Our reference: DOC16/230478-01
Contact: Stefan Press, (02) 6229 7002

**RE: Shoalhaven Starches Pty Ltd – Bolong Rd Bomaderry –
Ethanol Expansion - Packing Plant Modification - Project Approval 06_0228**

ATTACHMENT 1

Noise Barrier Walls

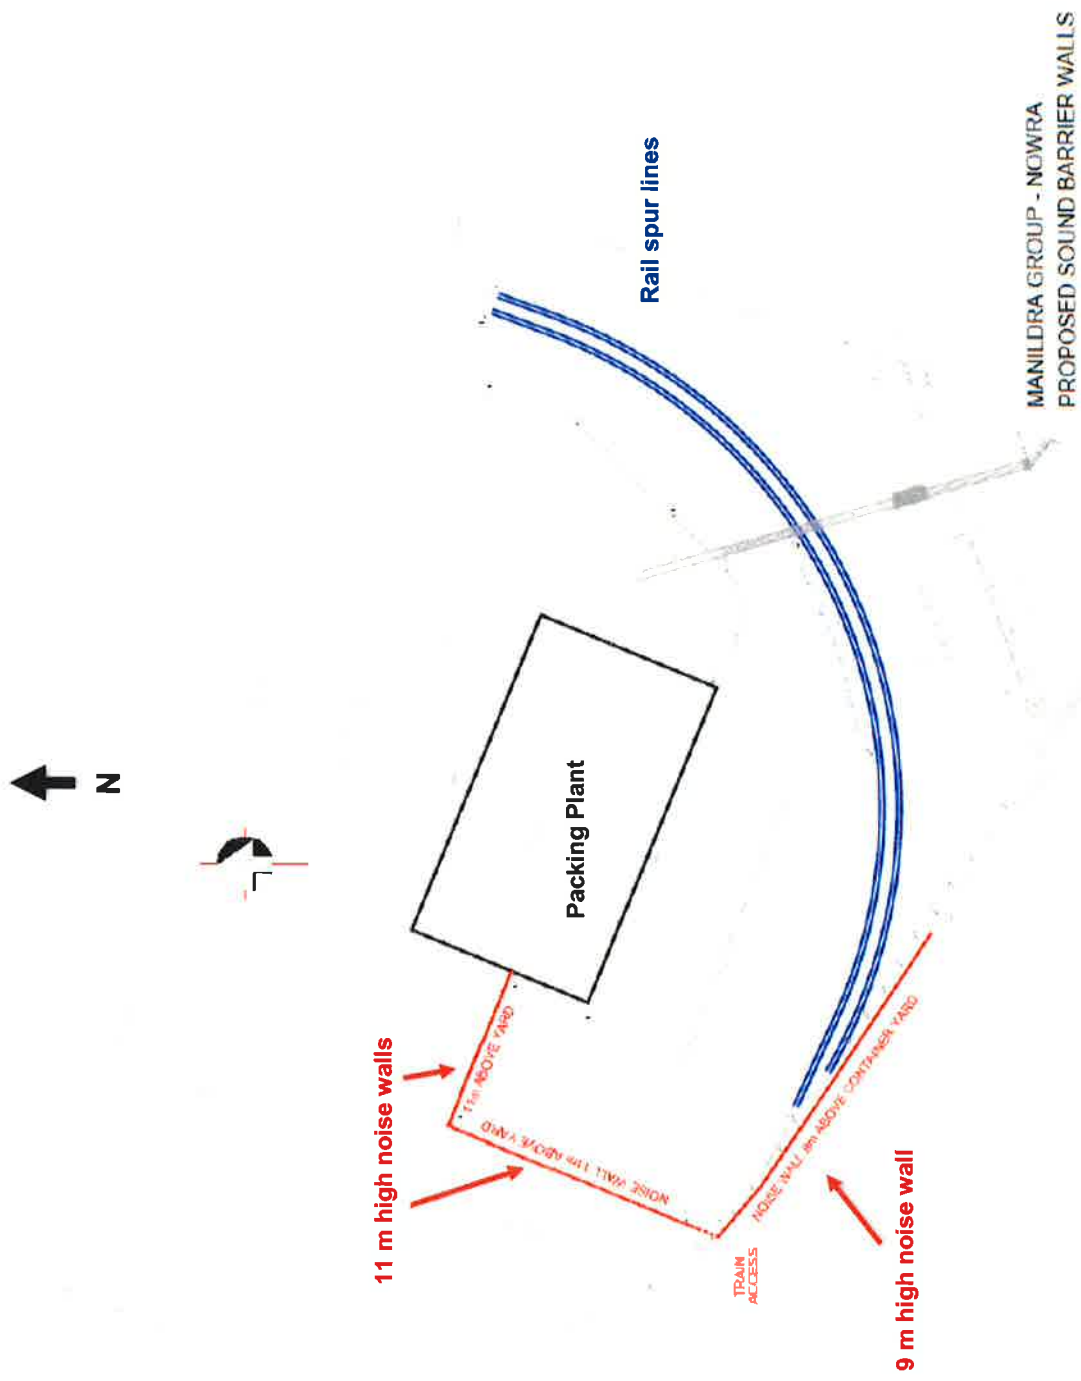
- Implementation of the noise mitigation measures contained in section 7 of the noise impact assessment report. In this regard it is recommended that the proposed container area noise barrier to be erected along the north western, north eastern and south western boundaries be constructed as a permanent structure such as a masonry wall to the recommended heights as the suggested use of movable shipping containers for this purpose is not considered to be a permanent solution.
- A noise validation assessment be undertaken within the first 12 months of operation of the new packing to confirm that noise emissions comply with the predictions in the noise impact assessment report and if not, all reasonable and feasible noise mitigation measures are implement to achieve compliance.
